**Building Inspections - Re: Roof deck - Munjoy Hill**

**From:** Ryan FitzGerald <[ryan.fitzgerald.17@gmail.com](mailto:ryan.fitzgerald.17@gmail.com)>  
**To:** Building Inspections <[buildinginspections@portlandmaine.gov](mailto:buildinginspections@portlandmaine.gov)>  
**Date:** 6/23/2014 1:57 PM  
**Subject:** Re: Roof deck - Munjoy Hill

One other question - the roof deck is going to be 28'x19.5'. It will be set back 2' from the edge on three sides, and on the fourth side the roof continues out another 40 feet or so. My question is, on the side that is not on the edge, do I need a railing? I was considering putting in planters (in grey) and leaving a section open for access to the rest of the roof.

# KEY PLAN

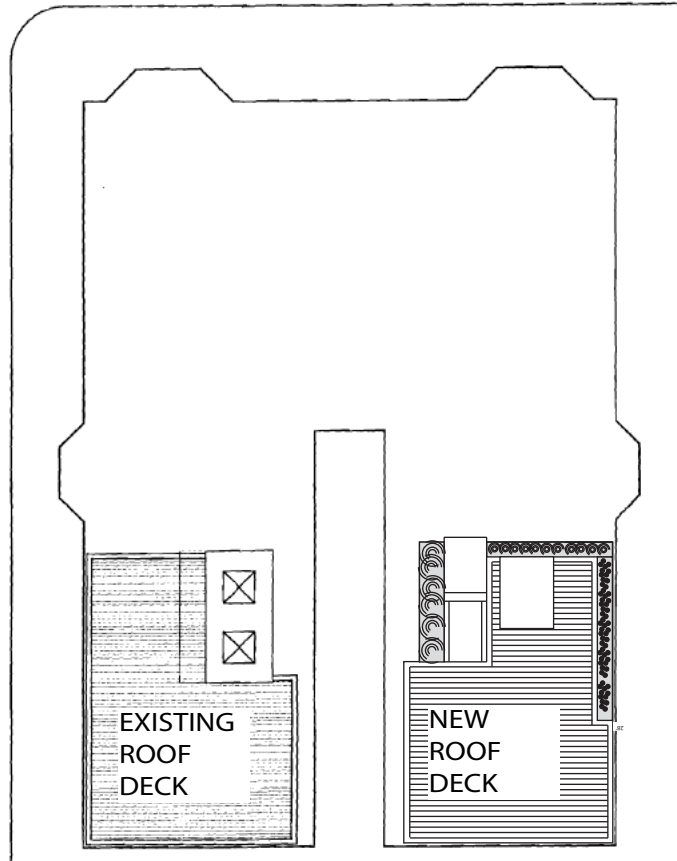
Ryan, you will also need to provide dimensions on your key plan (ie; plot plan). These 2 items are requirements.

Sorry bout that - cost of work is \$20,000. What dimensions do you need on the key plan? Just the deck dimensions?
